From: Brian Banister [REDACTED]
Sent: 14 November 2021 17:53
To: Planning.Responses <Planning.Responses@arun.gov.uk>
Subject: Re: Planning Consultation on: BR/253/21/L

Thankyou for the consultation. The views of the **Arun District Conservation Area Advisory Panel** are as follows:

Application No:	BR/253/21/L
Registered:	2nd November 2021
Site Address:	65-71 Upper Bognor Road Bognor Regis PO21 1HR
Grid Reference:	494178 99626
Description of Works:	Listed building consent for alterations to four listed buildings involving insertion of new windows, insertion of a new staircase, repairs and reinforcement of existing timber floors and roofs, removal of internal walls, forming openings in existing internal walls, erection of new internal partitions; extension of a listed building to create an office and warden's accommodation; erection of new building consisting of 3 No. flats, offices and workshops; creation of new private gardens, separation of this part of the site from the wider University campus, creation of a shared landscaped courtyard, creation of areas for parking and storage for bins and cycles.

Upper Bogmor Road Residential Redevelopment Bognor Regis	
Drawing 67 & 69 Upper Bognor Road Elevations As Proposed	
Scale @ A3 1:100	Drawing no. 5557-103-D2

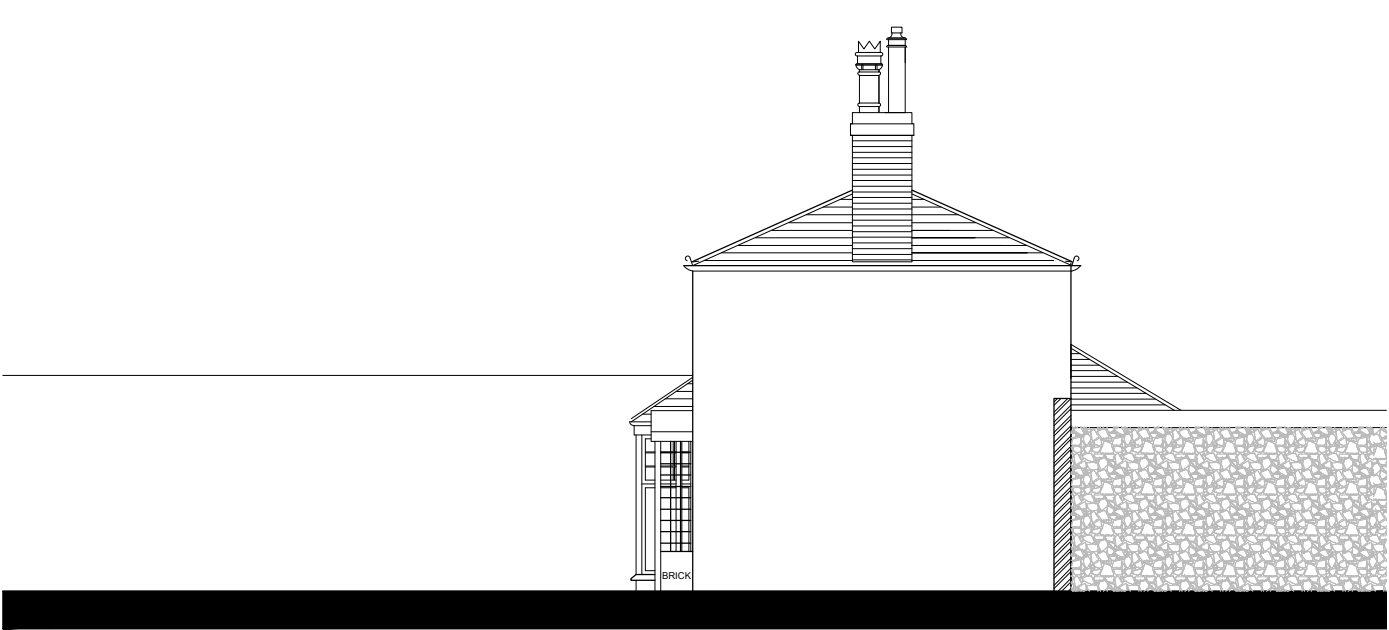
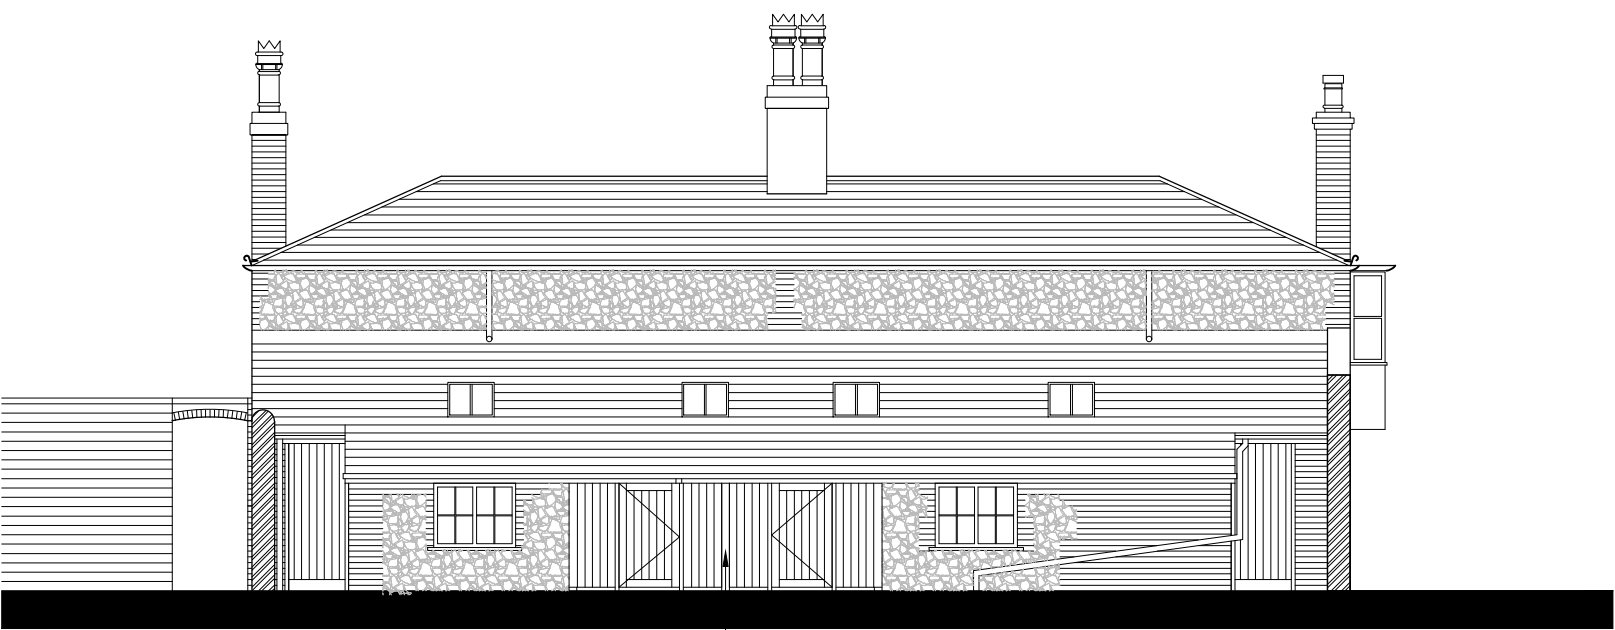
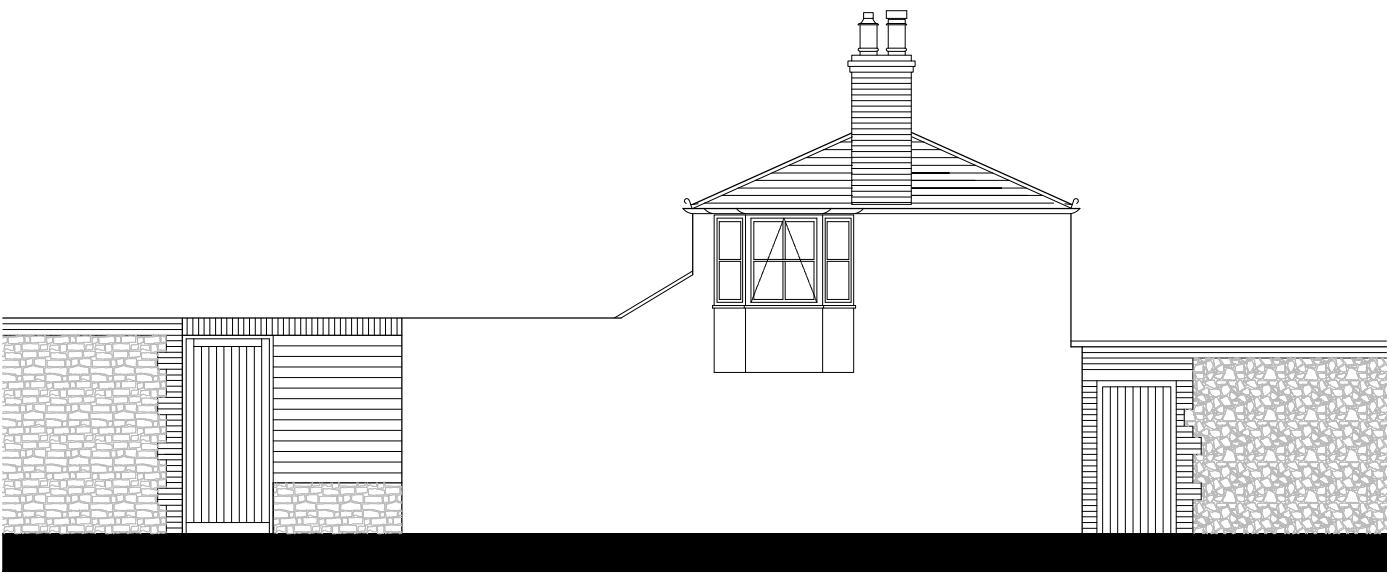
The Panel would suggest though that conservation roof lights should be used where roof lights are shown on the plans. In respect of any new or replacement windows relating to the listed buildings or extensions to them then precise details of fenestration needs to be submitted to ensure that the new windows are of an appropriate design in every way for historic buildings. Samples of the new natural slates also need to be submitted for agreement.
